Charlotte Department of Transportation Memorandum

Subject: Rezoning Petition 04-123: Northeast intersection of Driwood Court and
Mallard Creek Road

Subject: Rezoning Petition 04-123: Northeast intersection of Driwood Court and
Mallard Creek Road

Title: **REZONING PLAN**

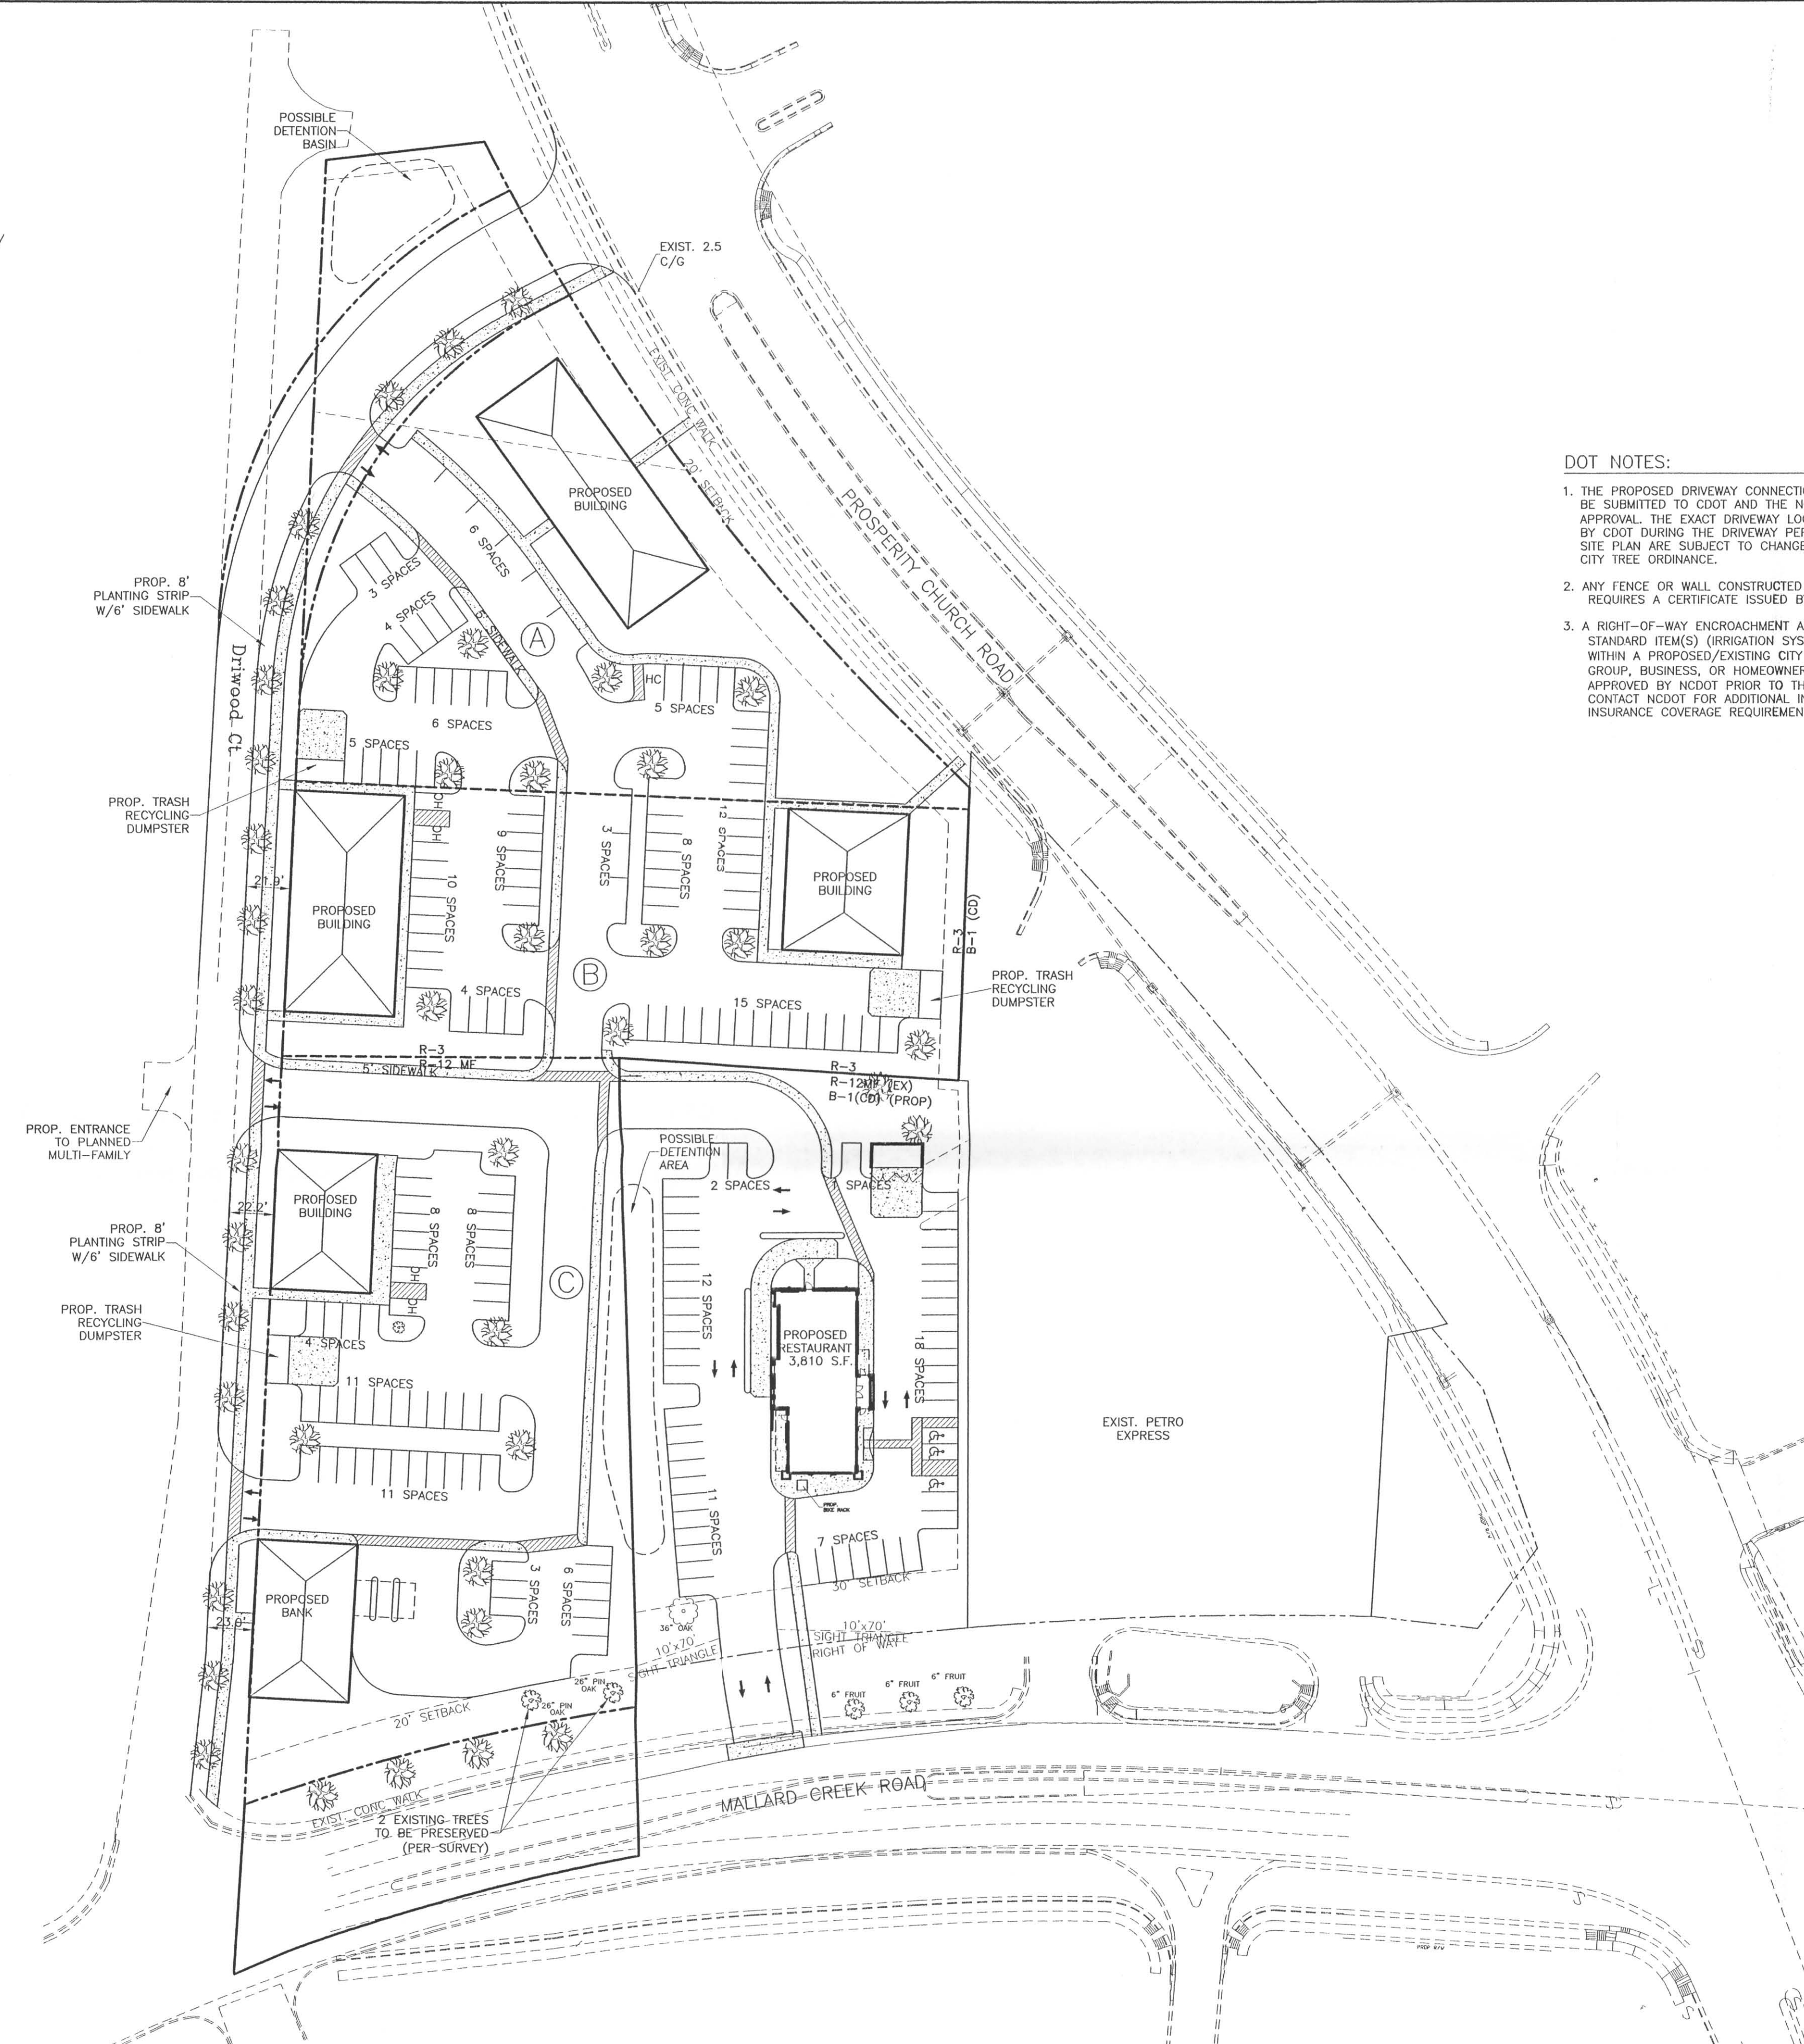
1. NS zoning requires construction of 8-foot planting strips and 6-foot sidewalks along all public street frontages. These sidewalks and planting strips must be constructed on Prosperity Church Road and Mallard Creek Road, not just Driwood Court as shown on the site plan. (*Second request*)

2. As shown on the site plan, the extension of Driwood Court does not meet minimum standards for commercial collector streets. Note 18 indicates that the developer commits to dedicating the right-of-way for the extension of Driwood Court in conformance with commercial collector public street standards. The extension of Driwood Court must also be designed and constructed in conformance with the commercial street standards. Meeting collector street standards will likely eliminate the three existing oak trees currently being shown to be saved in the northwest part of the site. CDOT can support using a portion of the commercial/collector street width as on-street parallel parking provided that adequate sight distance is maintained at each driveway.

1. If this property is rezoned, there will no longer be any single-family residences on Driwood Court, which was severed from Prosperity Church Road because it would have provided a route for cut-through traffic. With the absence of single-family residences and the intensification of land use along it, Driwood Court needs to be reconnected to Prosperity Church Road and aligned opposite the full-movement Type III driveway to the Food Lion shopping center. This will provide for more efficient dispersion of the traffic generated by this site without significantly impacting the intersection of Prosperity Church Road, Mallard Creek Road, and Mallard Creek Church Road.

2. NS zoning requires construction of 8-foot planting strips and 6-foot sidewalks along all public street frontages.
3. The pedestrian interconnectivity needs to be completed and better defined. The bank is separated from the rest of the site, as are the three proposed office buildings that front on Prosperity Church Road. Sidewalks also need to connect from this site to the proposed Bojangle's.

4. The petitioner/developer must commit to constructing the vehicular connection to the Bojangle's.
5. Any site driveways must align with, or not conflict with/overlap, any driveways for the multifamily development currently under construction across Driwood Court.

Mallard Creek Road and Prosperity Church Road are major thoroughfares requiring more than the minimum 100 feet of right of way because of their proximity to the signalized intersection. The developer/petitioner should convey right-of-way in fee simple title to meet this requirement, measuring 60 feet from the centerline of Mallard Creek Road and 70 feet from the centerline of Prosperity Church Road.

Adequate sight distance triangles must be reserved at the proposed entrances. Two 35' x 35' sight triangles are required for the entrances to meet sight distance requirements. All proposed trees, berms, walls, fences, and/or identification signs must not interfere with sight distance at the entrances. Such items should be identified on the site plan.

- Dimension width of the existing and proposed driveways. Minimum width for a two-way driveway is 26 feet and for a one-way driveway is 20 feet.
- New driveways must be drop curb ramp Type II-modified driveways (with radii, CMLDS #10.25-E).
- Indicate the locations and widths of all adjacent and opposing driveways.
- Indicate typical parking module dimensions.
- Include a parking summary with figures for the numbers of parking spaces required and provided.
